Your Ref: OWPC14323
Our Ref: M/42/17/HH 03-05-2017
Please ask for:
Mrs A Gardner

Demolition of 1 No. shed & garage & erection of two storey side extension, driveway & entrance gates.

14B Sea Way Middleton on Sea

Thank you for your internet representation made on 22nd June 2017 which has been recorded as '**an objection**' with the comments as follows:

Proposed Entrance Gates Elevation
Scale - 1:50

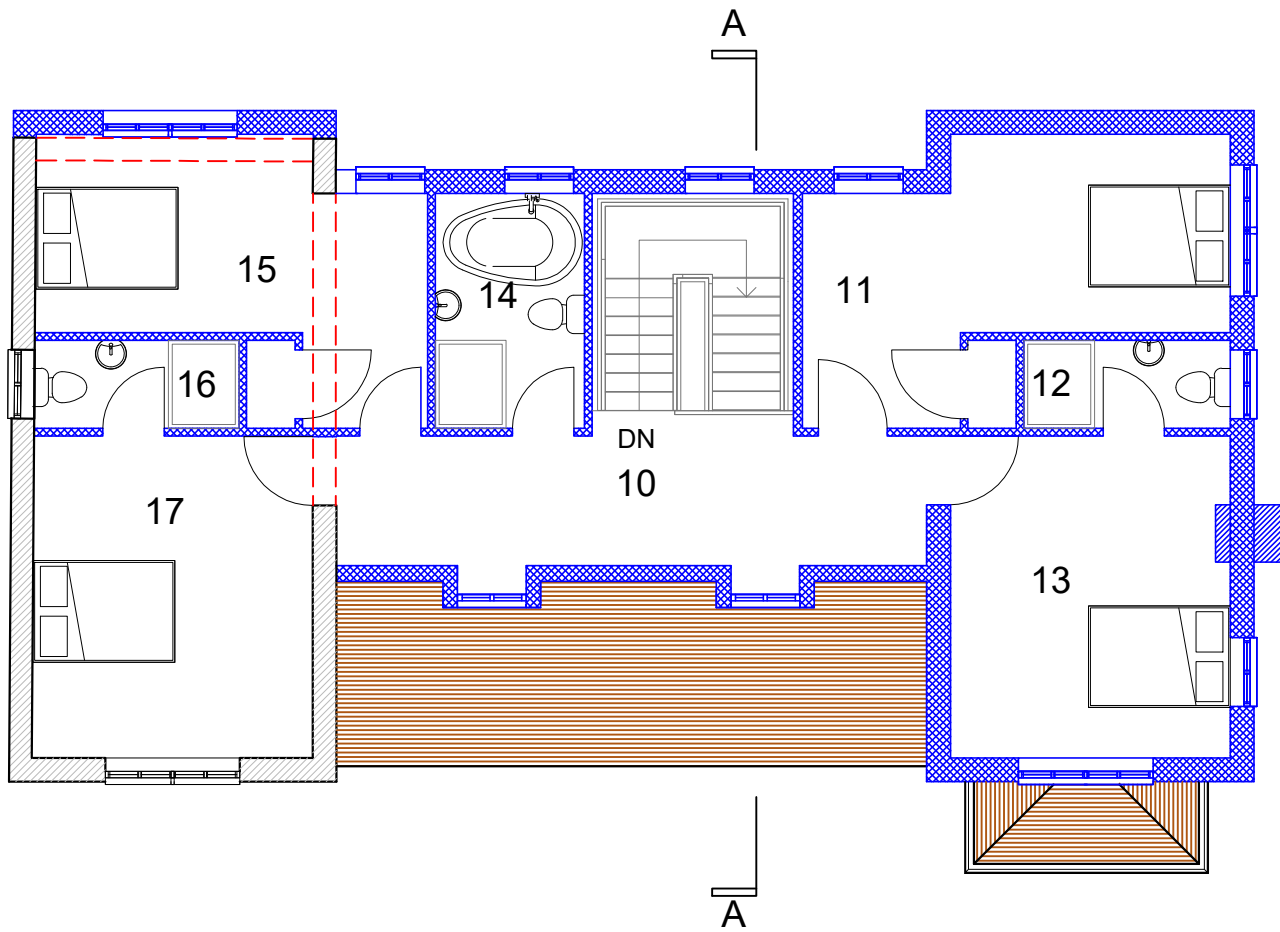
- 4. Entrance to the proposed drive is far too close to the entrances of its immediate neighbours, 14 and 14a making any vehicular movements to and from the new development difficult and possibly dangerous. Exiting the property would require a number of manoeuvres and add to annoyance from noise and environmental pollution from cold vehicle operation. Due to the size of the proposed parking area it is difficult to imagine that anything other than reversing out will be possible adding to the danger with restricted vision due to walls, fences and gates.*

Site Plan
Scale - 1:500

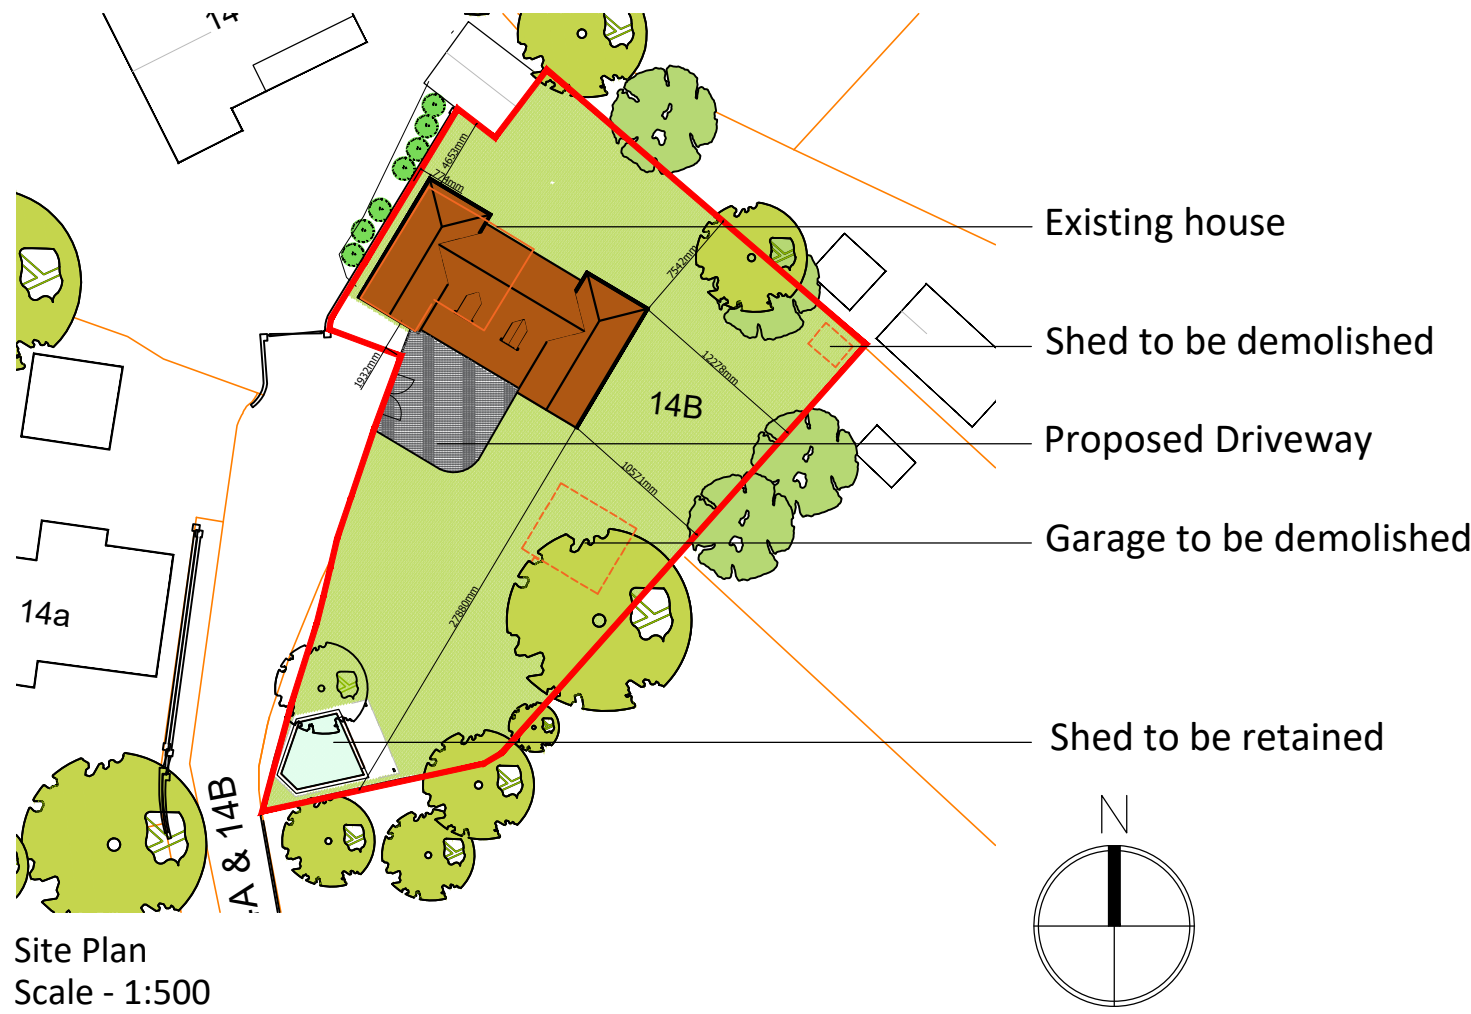
- 1. It is an over-intensive development for a site of that size within an Area of Special Character compromising the character and spaciousness of the surrounding properties.*

- 2. It overlooks 5 adjoining properties, invading their privacy.*
- 3. It is virtually on the NW boundary making it far too close to a neighbouring property. It is also higher than the current building.*
